**Application for a non-material amendment following a grant of planning permission,
Town and Country Planning Act 1990**

**Non material amendment to previous permission 2020/90417 for erection of single
storey extension**

1, Rose Mount, Birkby, Huddersfield, HD2 2BU

Application Number: 2021/91567

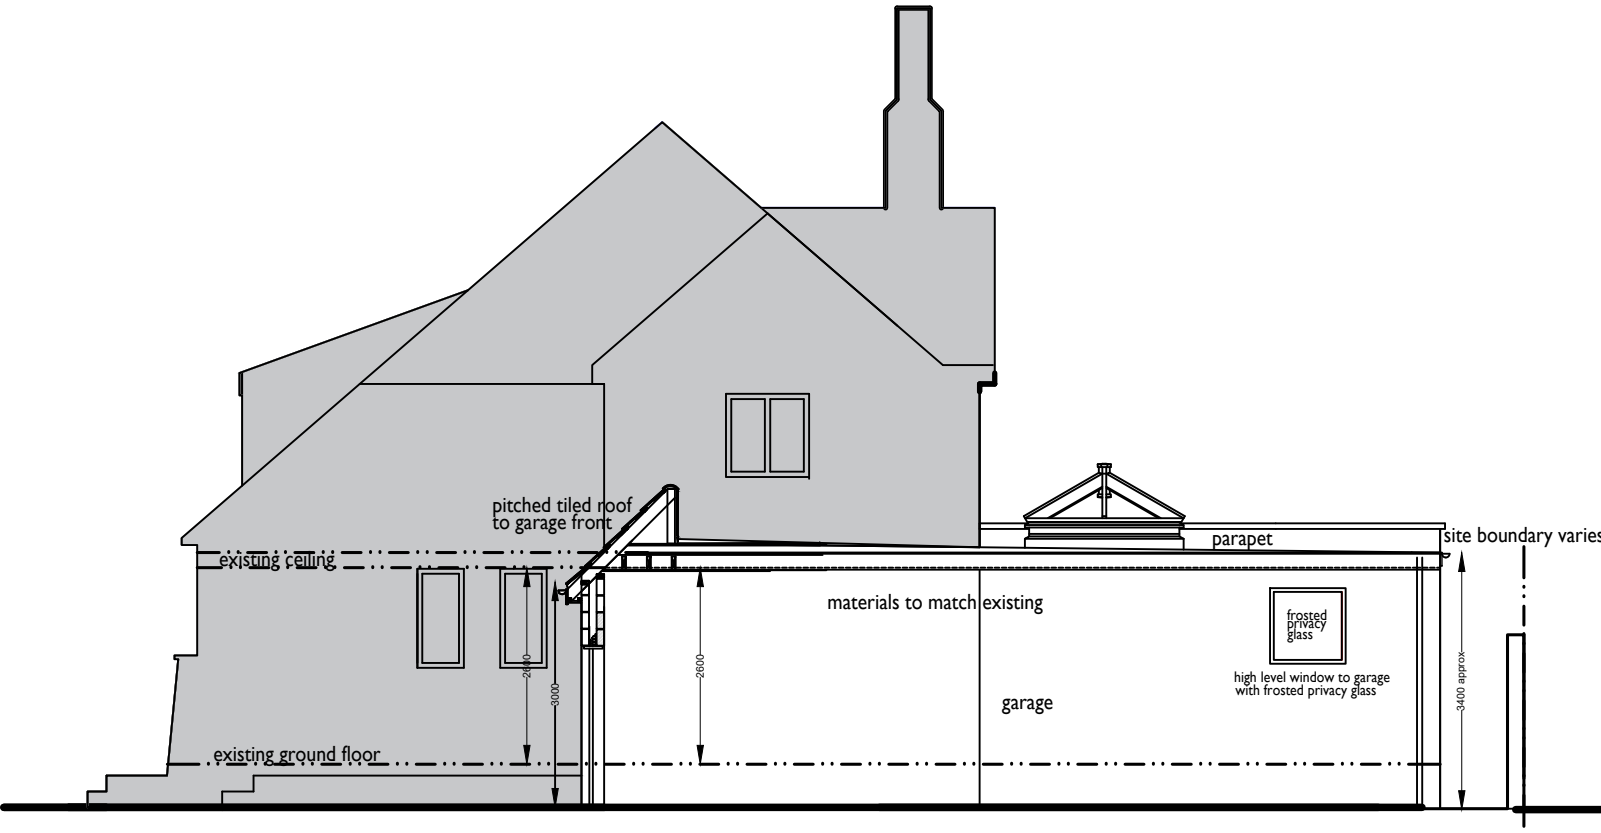
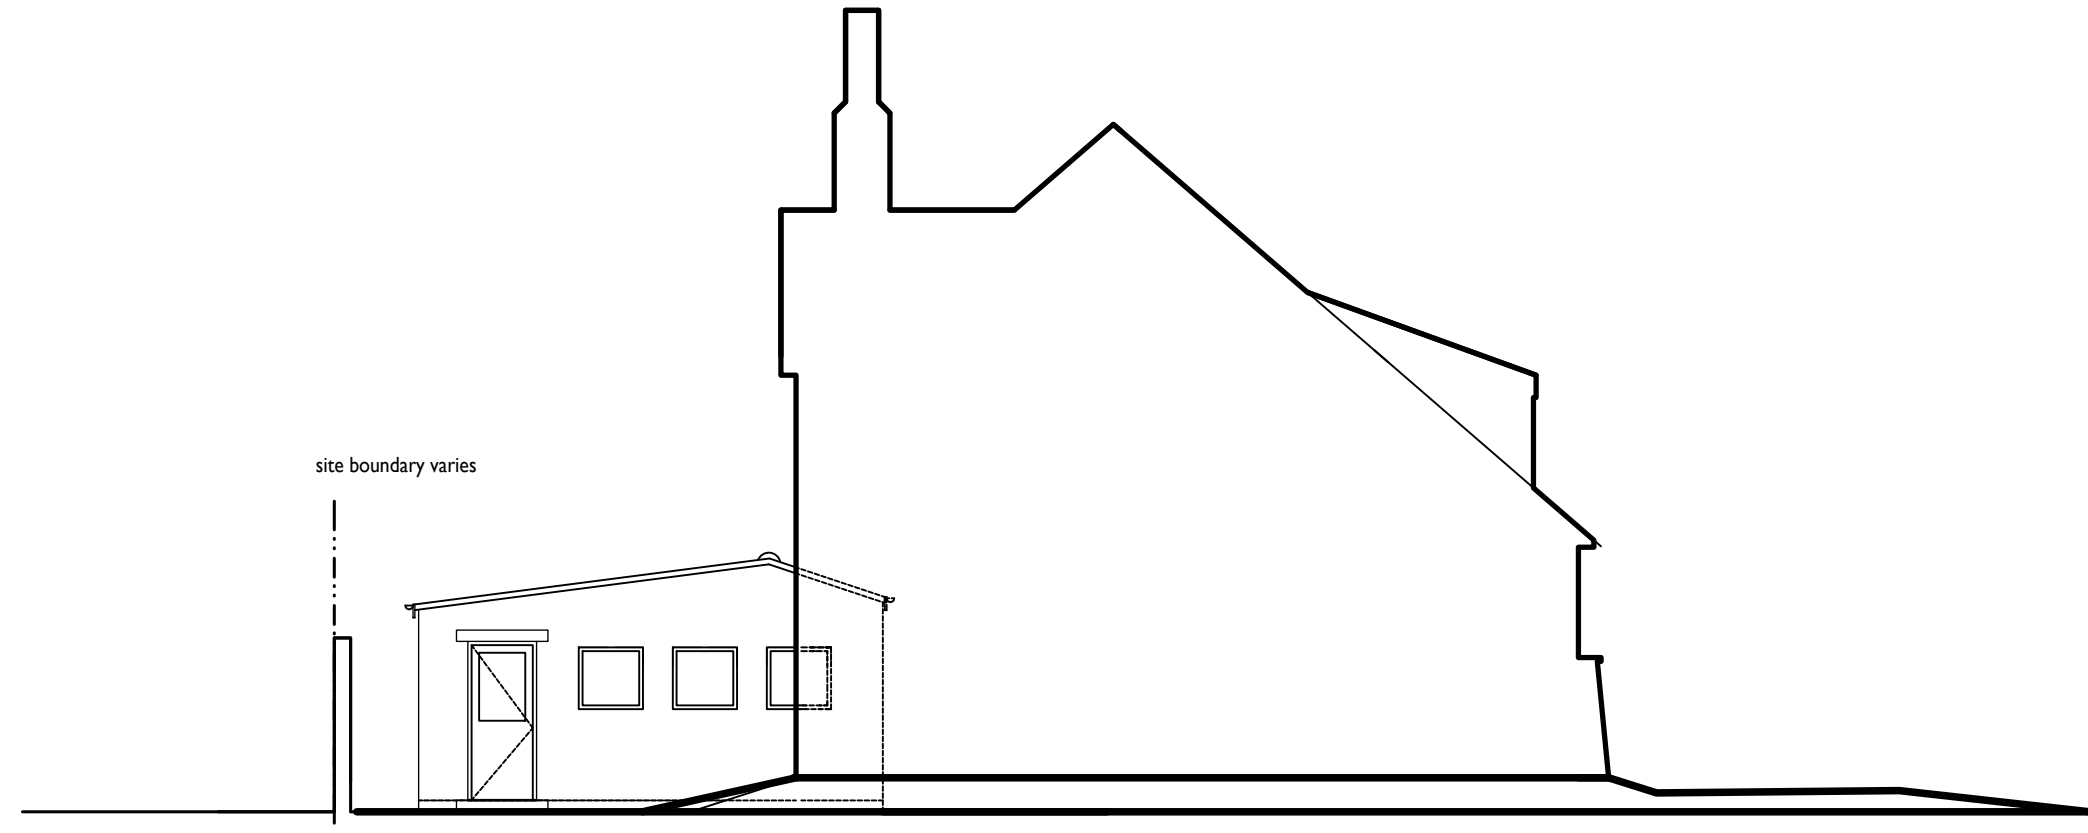
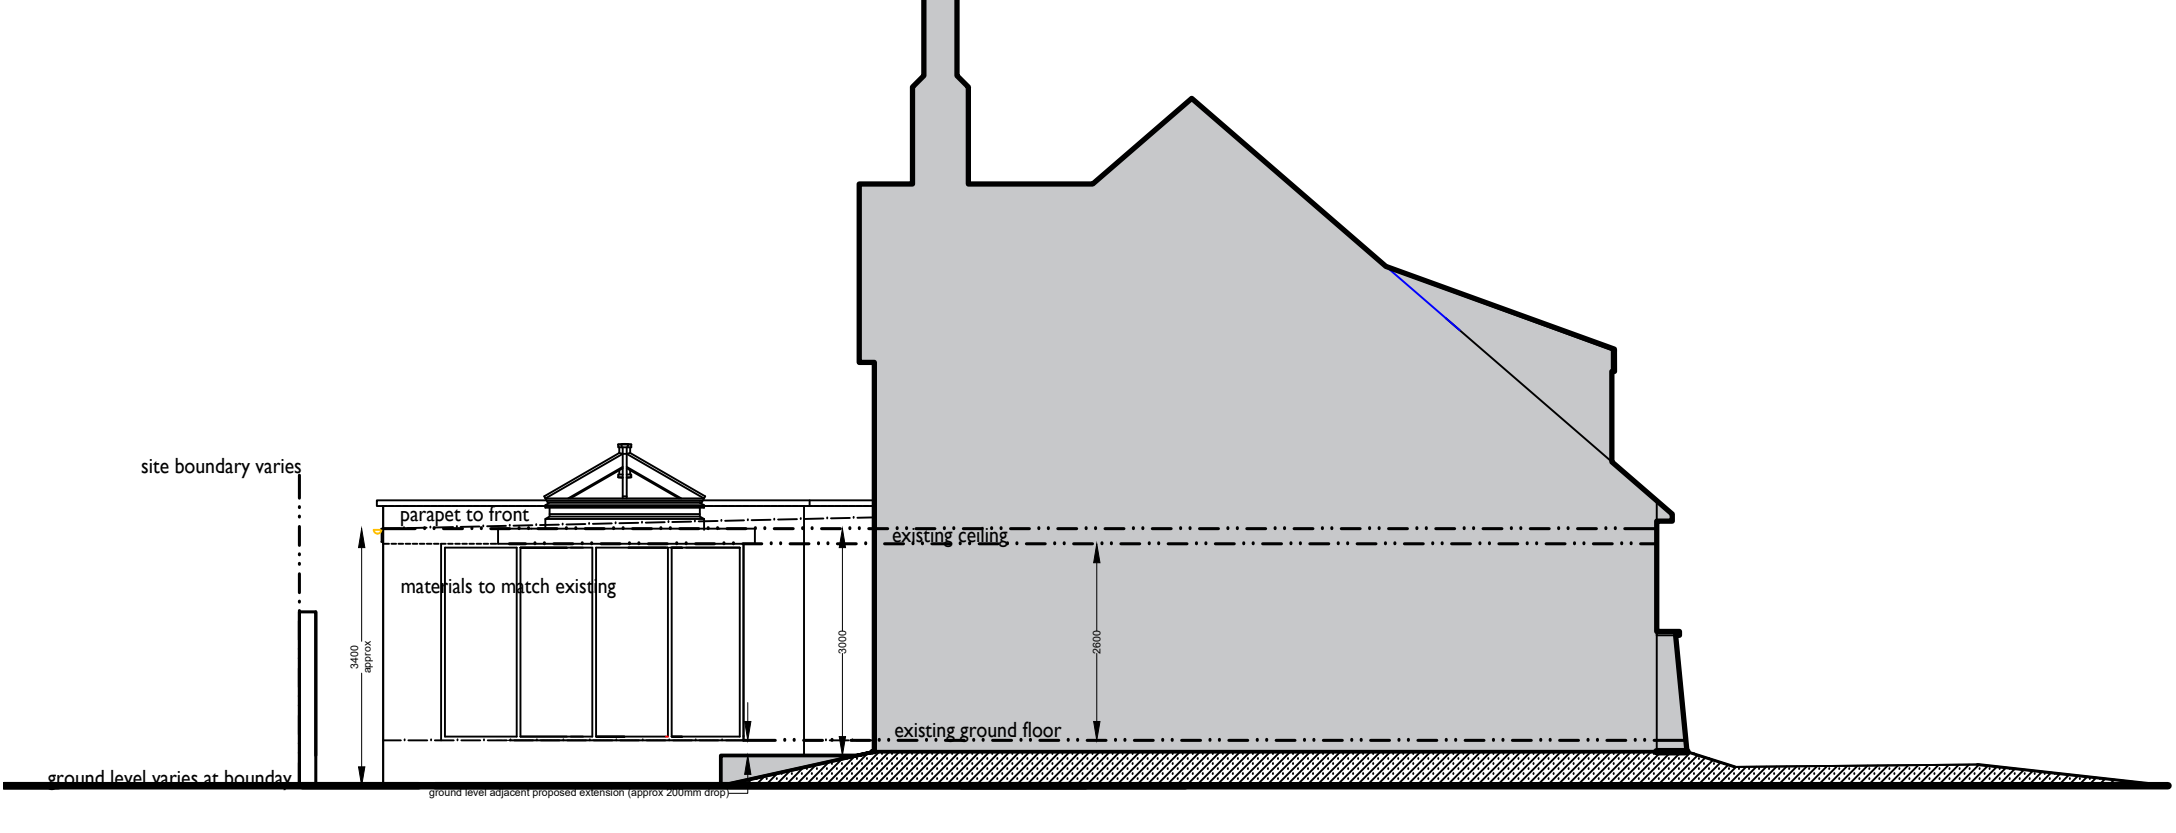
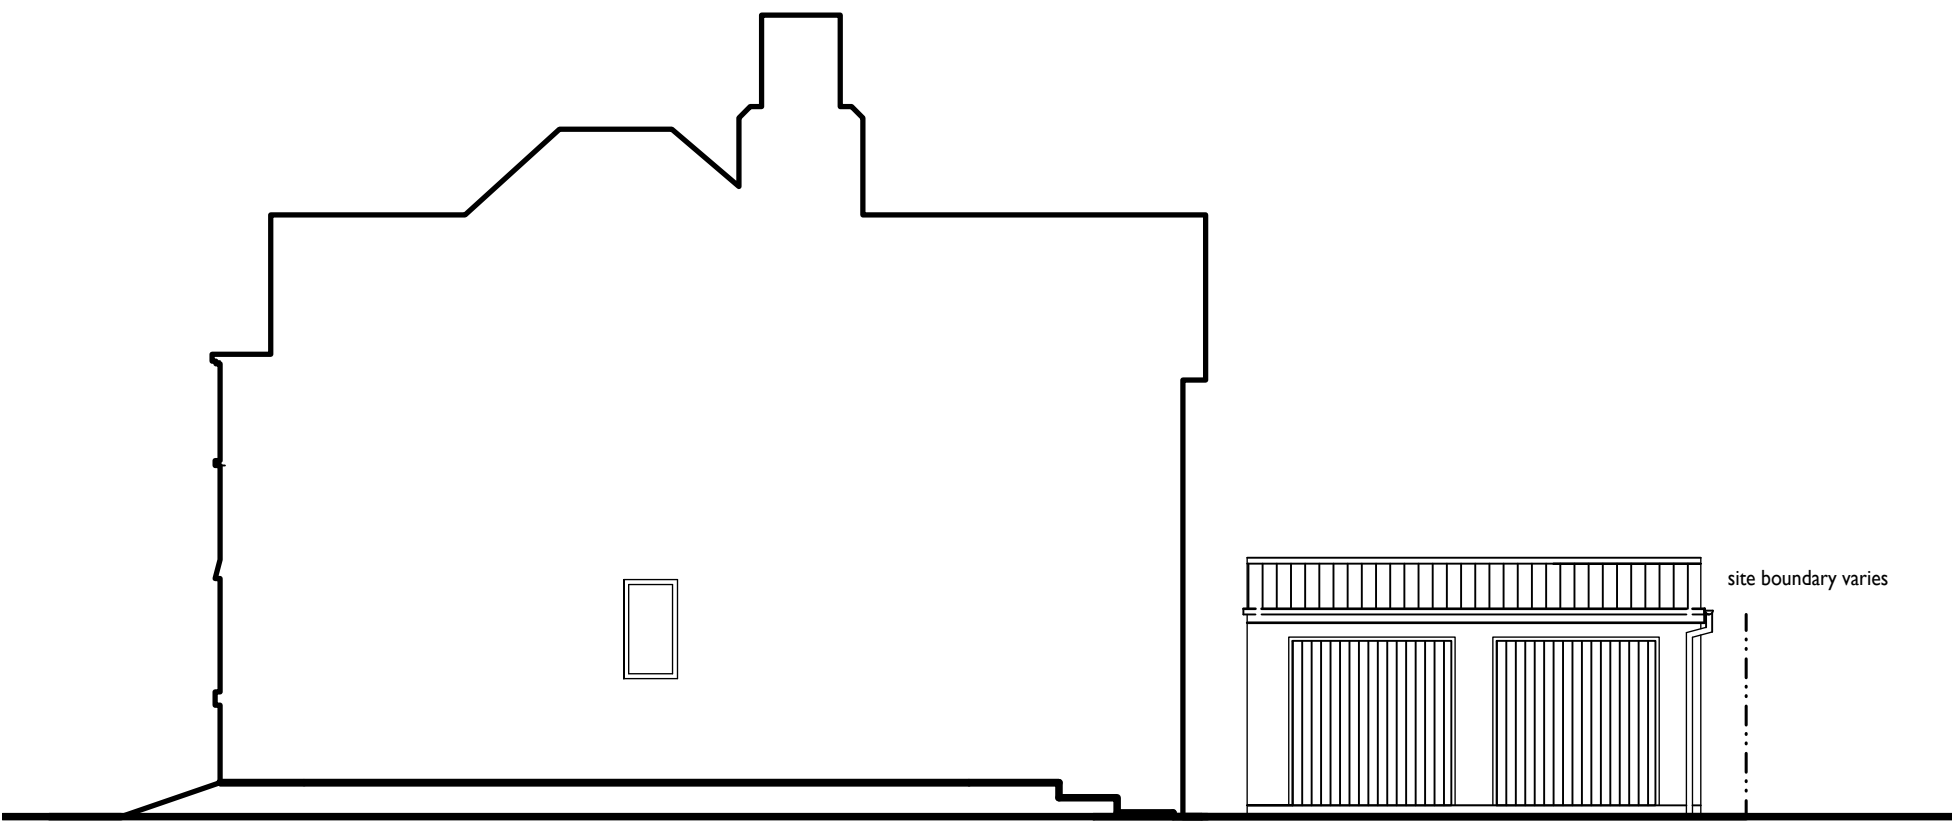
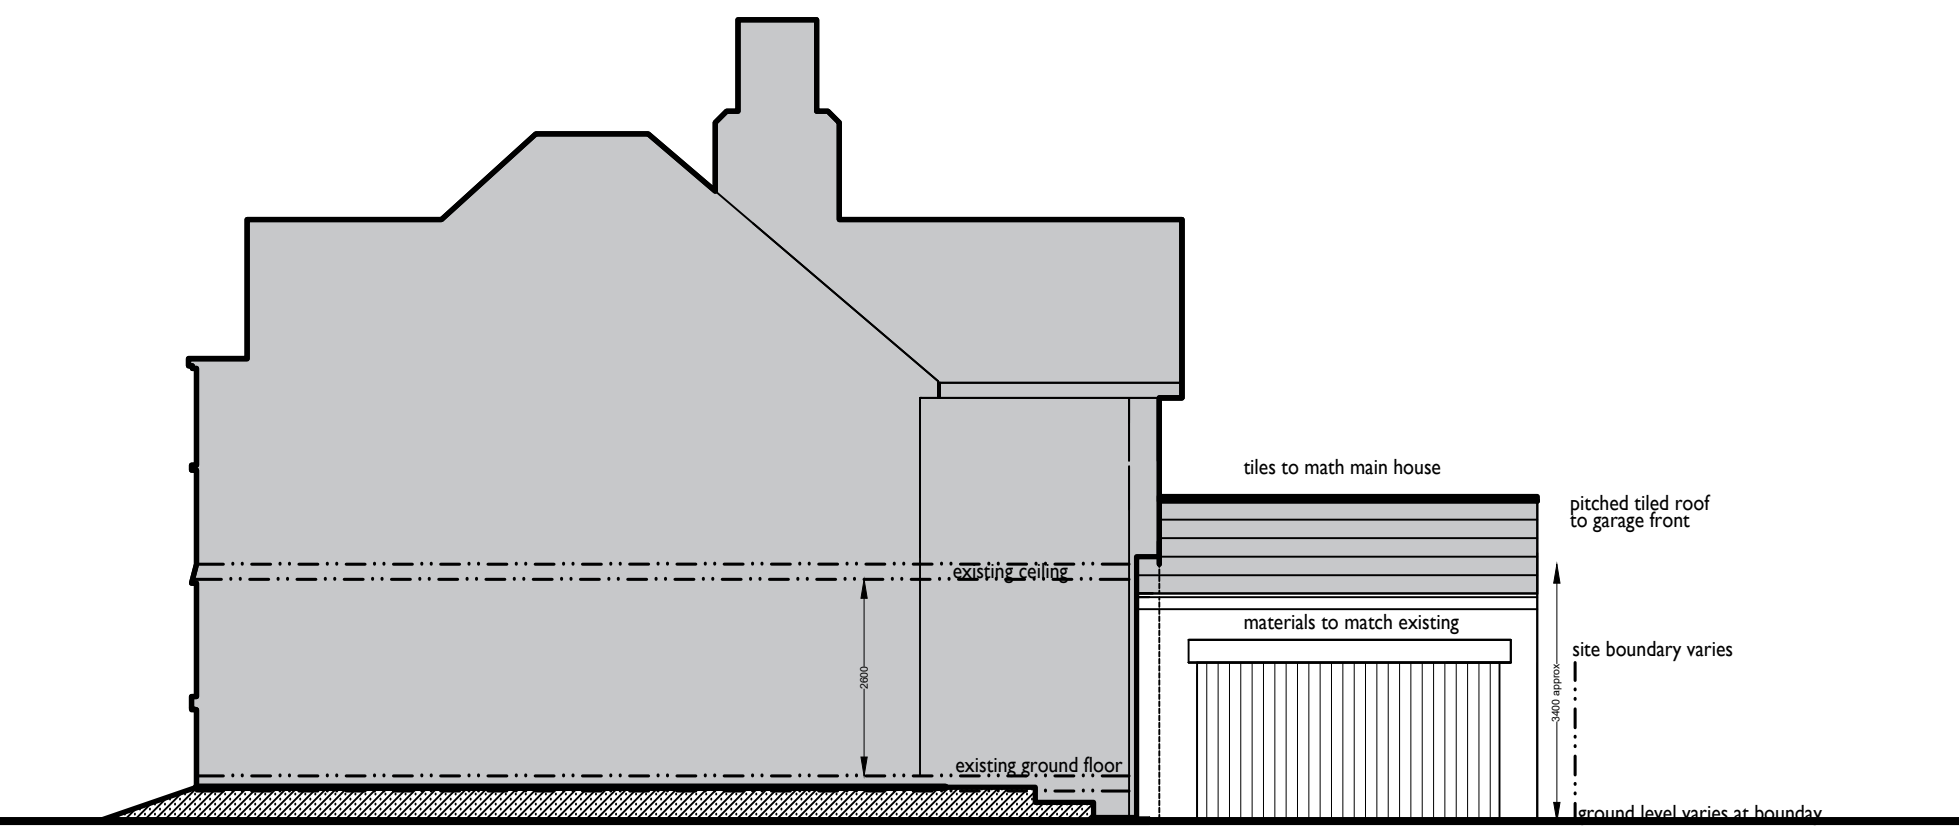
The amendment sought is for a longer roof lantern within the kitchen, a small set back to the rear wall of the garage and also a small pitch to the front of the garage roof as shown on drawing numbers Revision 01 Existing and Proposed Elevations and Revision 01 Existing and proposed Floor Plans.

Please note: This permission does not extend to the additional window openings within the side and rear elevations of the garage.

I confirm that the alterations are acceptable and may be considered as a non-material amendment to the approved drawings. It should be noted that this letter relates only to the non-material amendment sought and it is not a re-issue of the original planning permission. The two documents should be read together and as such, all conditions imposed on the original granting of planning permission apply to the proposal as now amended. A copy of this letter and the amended plans will be retained on the public record of approved documents.
